Application BE/151/11 with revised Layout Drawing "Proposal 01B"

Extension to existing caravan park to provide 12no. additional mobile homes, associated parking area, formation of access and construction of electrical intake housing.

Review of Layout Plans for The Shripney Garden Extension

Revision A - positions of mobile homes are indicative only 6/12/12
SHRIPNEY GARDEN CARAVAN PARK, SHRIPNEY
Proposals 01 A

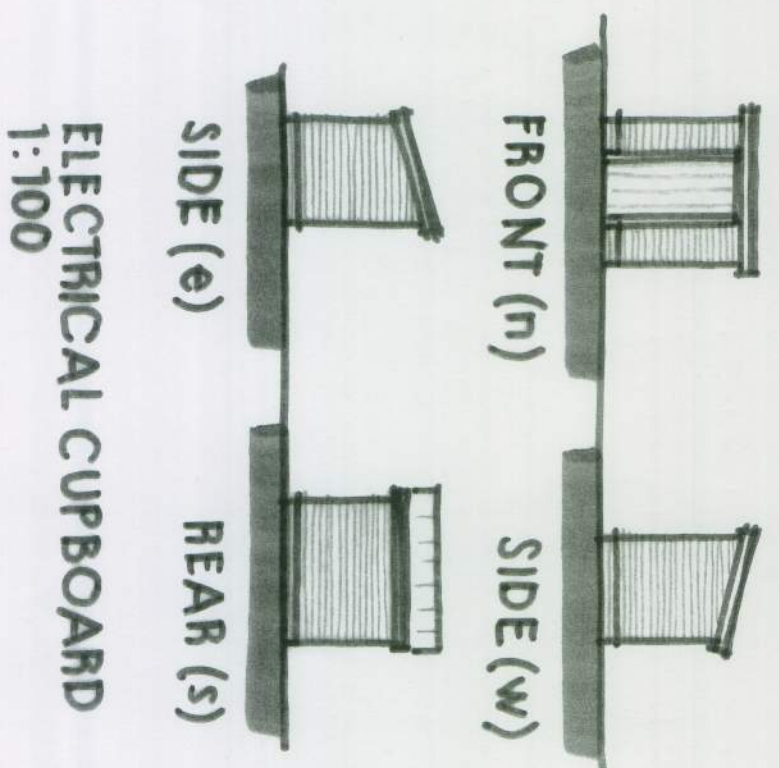
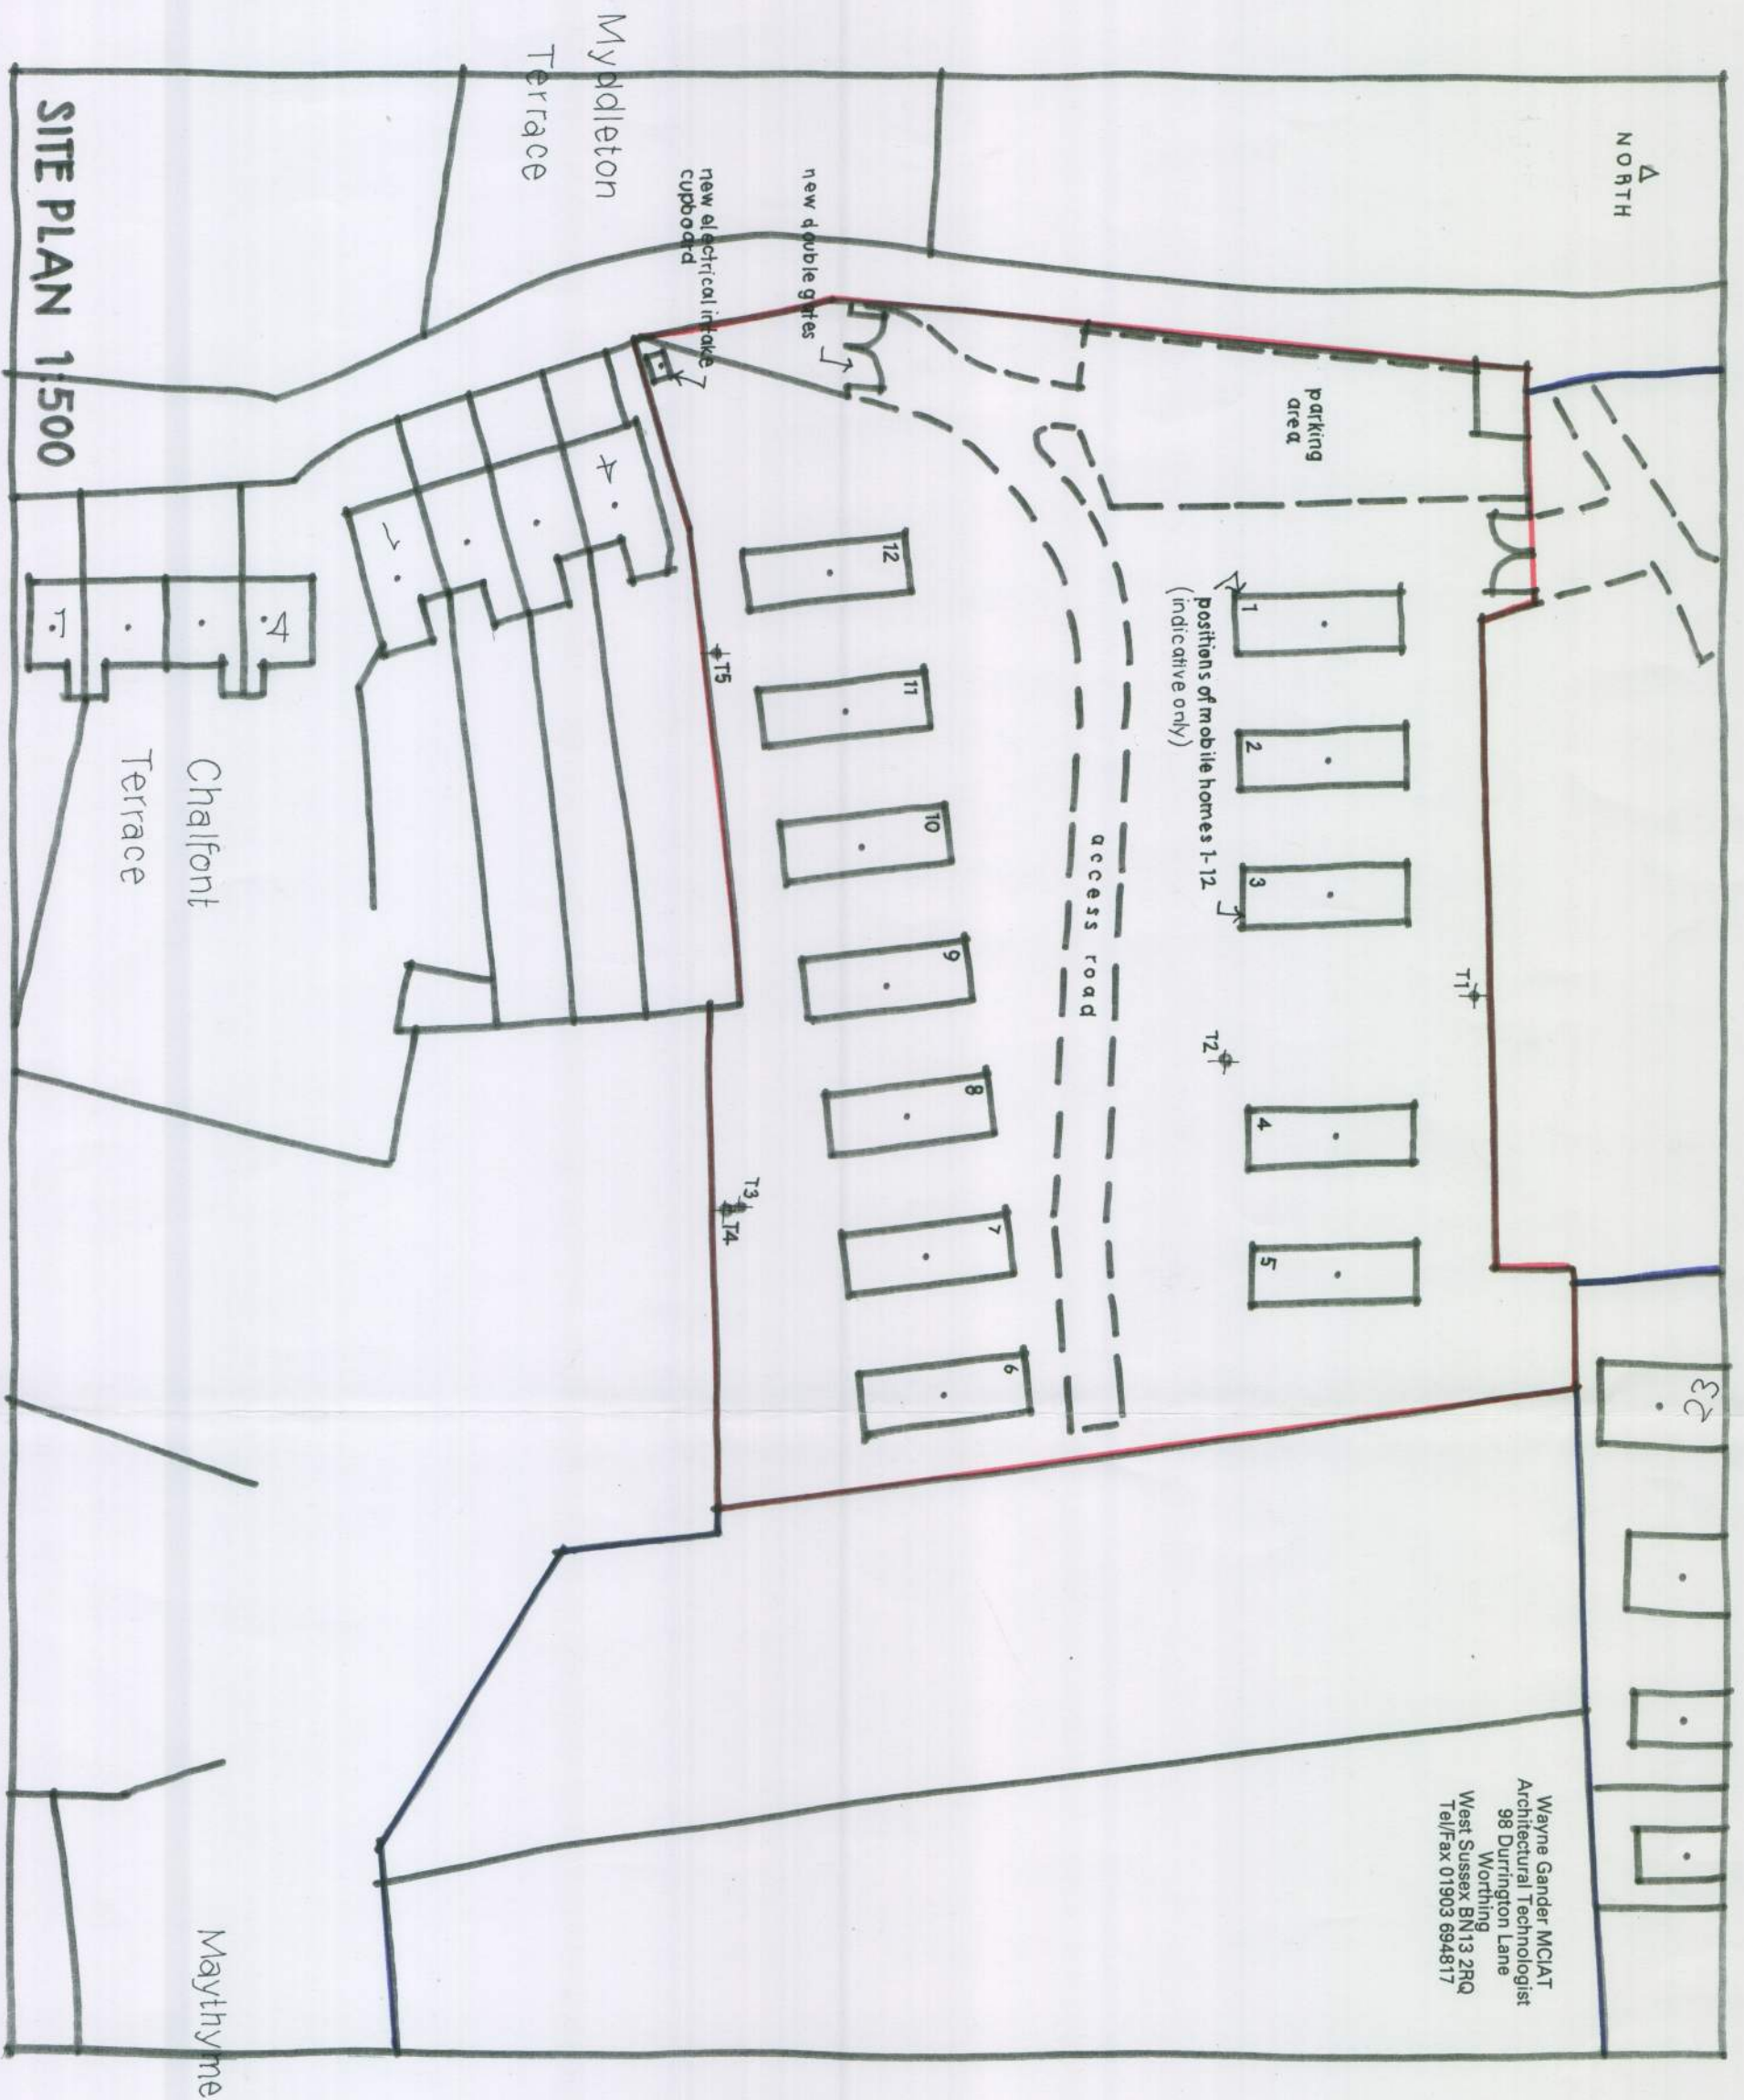
- 1) In 01A the words "indicative only" have been added beneath the original note that read; "Positions of mobile Homes 1-12 "

Item (1) above would probably be acceptable with some specific tolerances on the actual positions of the mobile homes, e.g. "plus or minus 0.5m in any direction", to prevent placement too close to the neighbouring domestic dwelling and conservation area.

No. BE 151 11

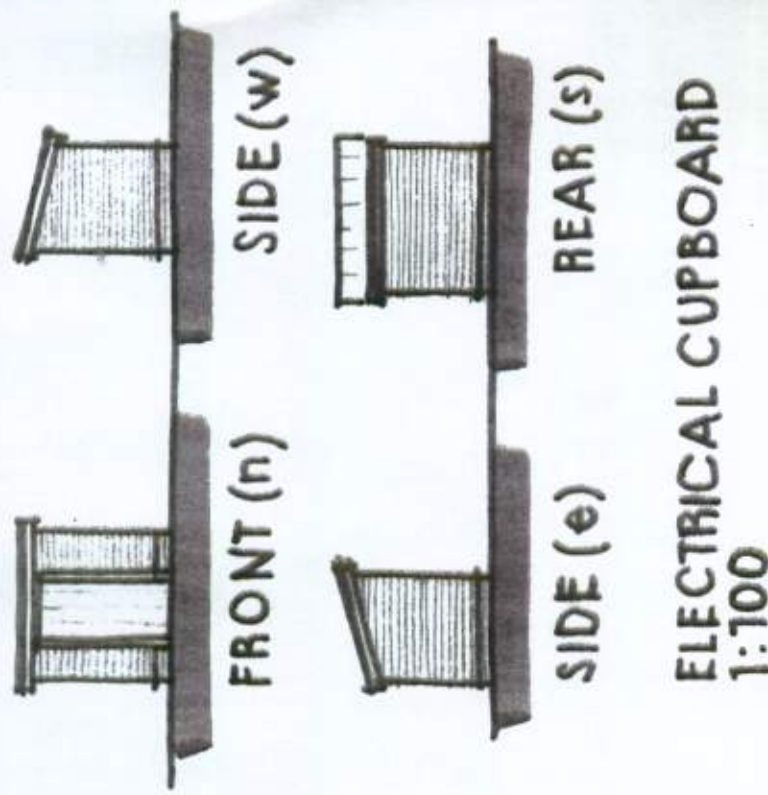
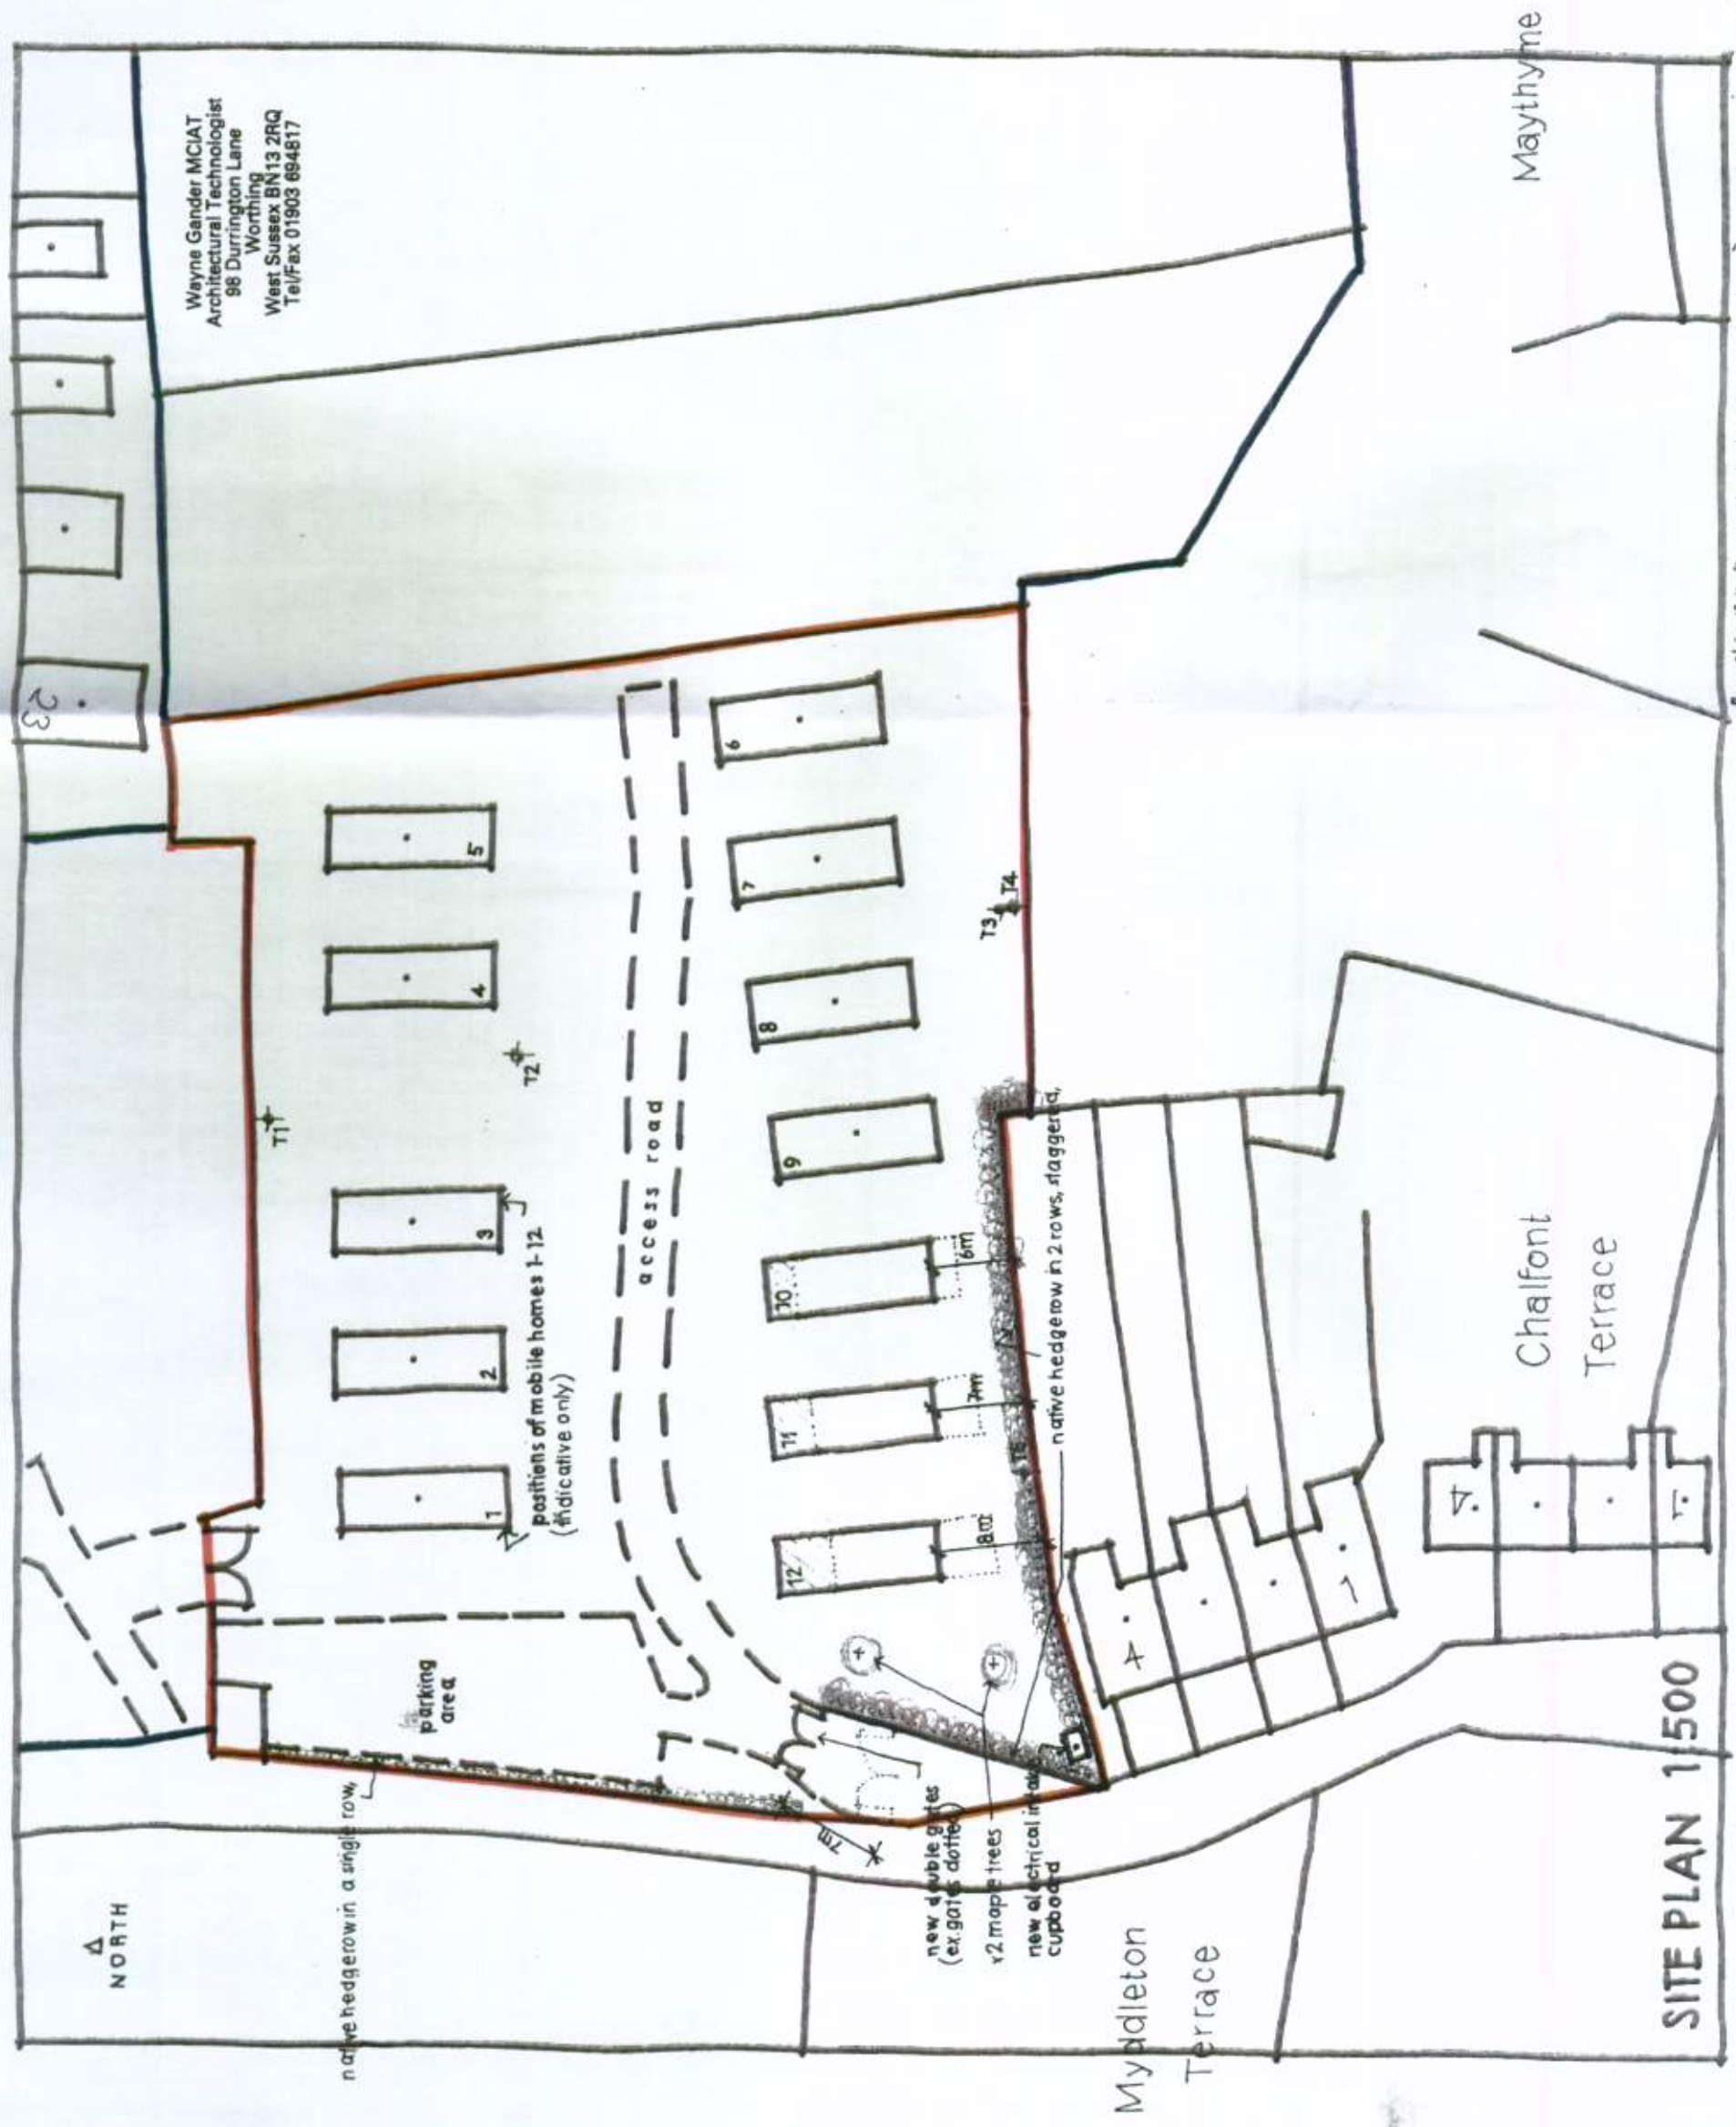
- 2) In 01B the new access gates have been relocated an indicated 7m further north, away from the adjoining residential dwelling known as 4 Myddleton Terrace.

- 3) In 01B the distances of mobile homes 10, 11 & 12 from the southern boundary fence have been increased to an indicated 6m, 7m & 8m, respectively. This moves them further away from the boundary to the adjacent conservation area and domestic dwelling.

- 4) 01B indicates the addition of 2 maple trees in the space between mobile home No 12 and the western boundary fence.
- 5) 01B indicates that a "native hedgerow in 2 rows, staggered" will be planted inside the portion of the southern boundary that borders No 4 Myddleton Terrace and inside the portion of the western boundary between No 4 Myddleton Terrace and the new access gates.

- 6) 01B indicates that a "native hedgerow in a single row" will be planted inside the portion of the western boundary between the new access gates and the northern boundary fence.

Item (2) above represents an improved position for the gates at approximately 20m from the boundary with No 4 Myddleton Terrace, however, the angled tarmac entrance still begins within 1m of that boundary, creating the potential for increased disturbance and increased risk to the occupiers of 4 Myddleton Terrace from vehicles using the access. This will be particularly true when large commercial vehicles visit the site to collect waste or to deliver goods and mobile homes.

Item (3) above represents an improved position for those mobile homes, with respect to their potential to create disturbance for No 4 Myddleton Terrace through overlooking and over-bearing presence. The relative positions would now be similar to the layout indicated on drawing AG/CL 2 in May 2010 and approved by ADC in July 2010.

Item (4), above, represents a potentially worse situation than on AG/CL 2, from 2 standpoints. Firstly, the southernmost of the proposed maple trees is shown only 5m from the boundary and only 6m from the house at No 4 Myddleton Terrace. Experts appear to recognise that the safe planting distance for a maple tree is between 12m and 20m from any building. Secondly, the potentially large crown that would grow on the maple trees would significantly reduce the light available to the house and garden at No 4 Myddleton Terrace.

Item (5), above, needs to be part of the landscaping plan that would require approval from the local authority. The requirements for the southern and western boundaries may, however, be different. The western boundary badly needs screening to replace that provided by the 1.8m brick wall that was demolished. The southern boundary that borders No 4 Myddleton Terrace must provide adequate privacy but not take light away from the house and garden. Expert opinion is required in the selection of specific species of hedge.

Item (6) above also needs to be part of an approved landscaping plan aimed at replacing

All of the layout drawings clearly show that the actual area developed is in fact 0.558 hectares, not the 0.429 hectares approved in application BE/42/10. This consumes even more grade 1 & 2 agricultural land, which is contrary to the provisions of PPS 7.
